SNPA ExQ1 Responses

Question 17.5 – SNPA and NRW raise concerns around under-reporting of significant effects. Please identify specifically where your concerns lie, with supporting reasons for this

Question 17.6 – SNPA’s RR makes reference to visual impacts from specific points within the National Park, such as from Carnedd Llywelyn and the Carneddau as a whole. Noting that VP10 is from Carnedd Llywelyn and VP is from Foel Fras;

Baseline photograph

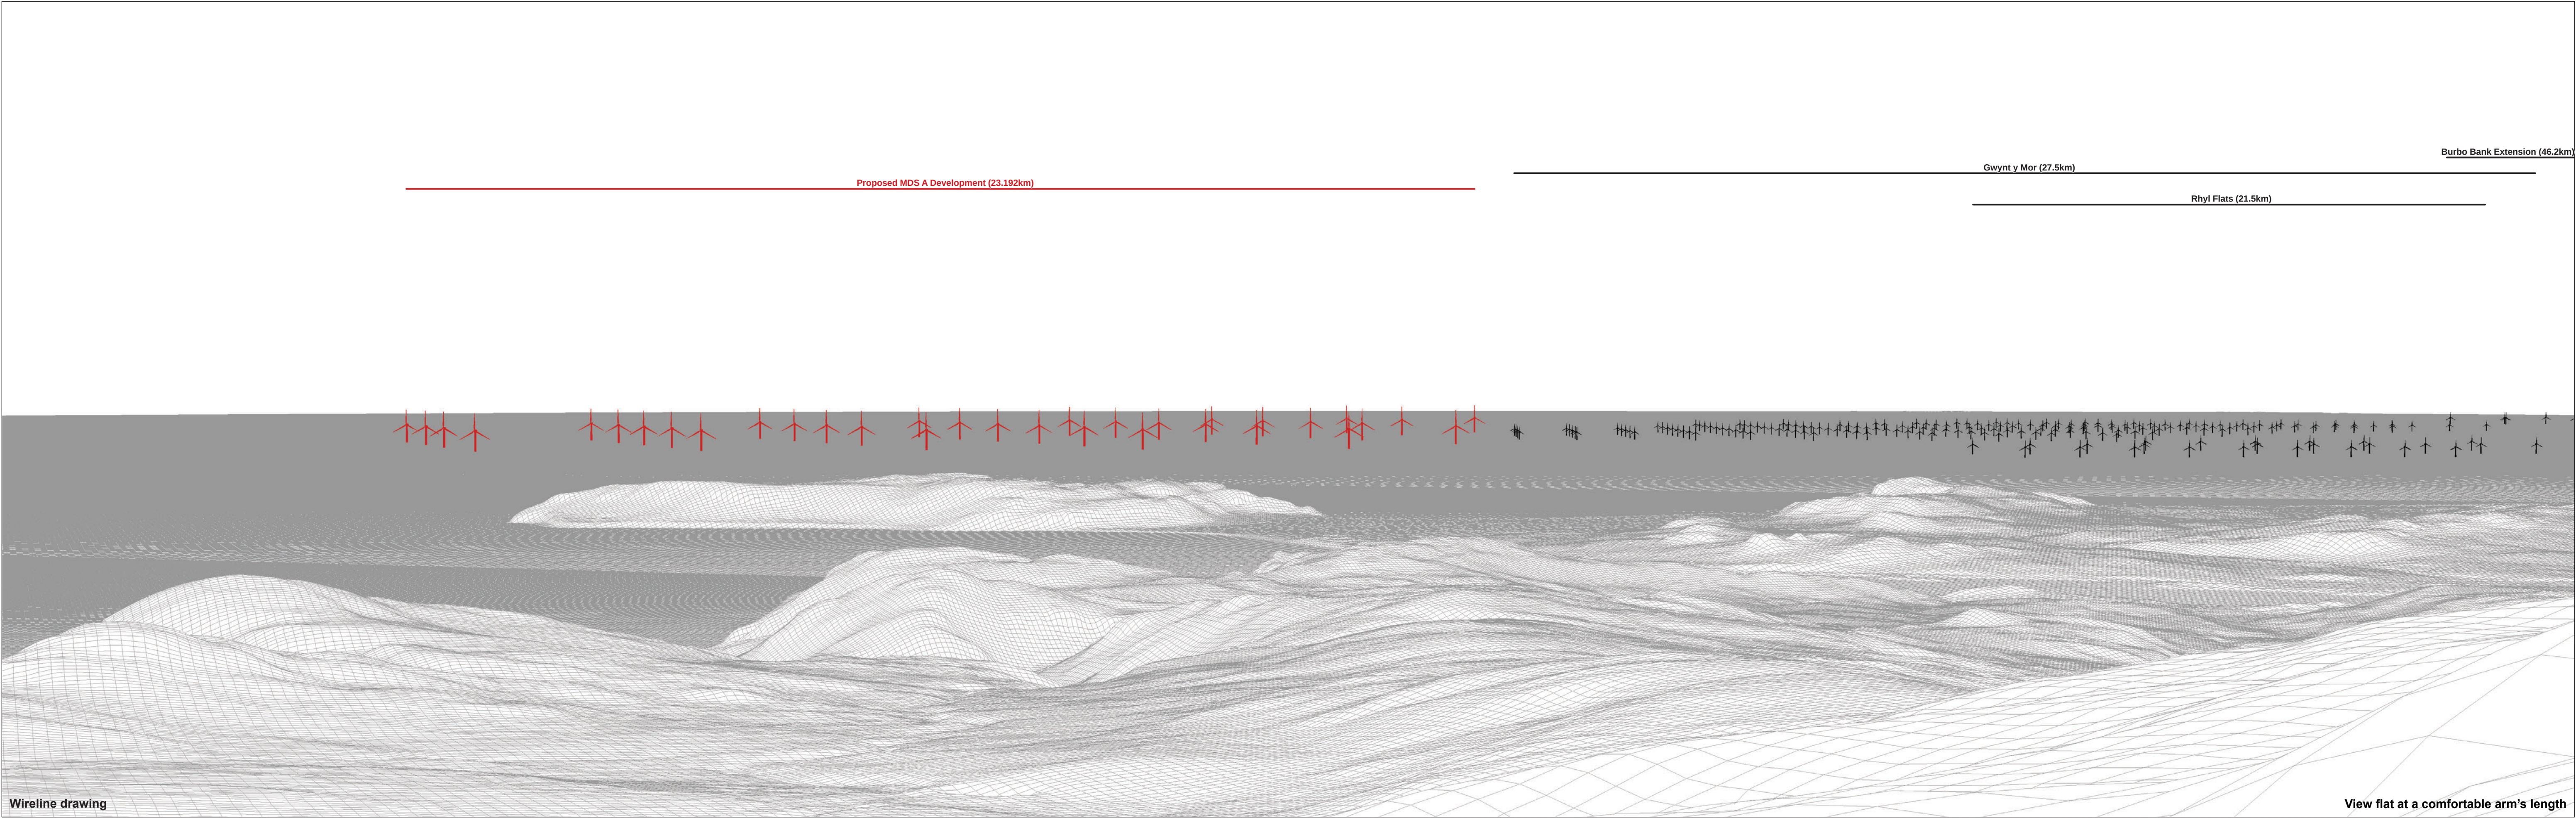
- The PEIR found significant effects at four of these, while we queried the finding of non-significant at VP36 Tal-y-Fan. Effects on the closer viewpoints 12 and 40 are recorded as major- moderate in the ES, with the more distant viewpoints 10 and 38 being moderate. A moderate-minor and non-significant effect is recorded at VP34 Snowdon Summit. The assessment for VP36 Tal-y-Fan is stated to be moderate but not significant. We suggest that, although close to the borderline, this should be identified as significant. We note that effects at VP38 Foel-fras are moderate (significant), on a very similar but more distant view. We highlight an inconsistency in the sensitivity assessment for VP36 that may account for this
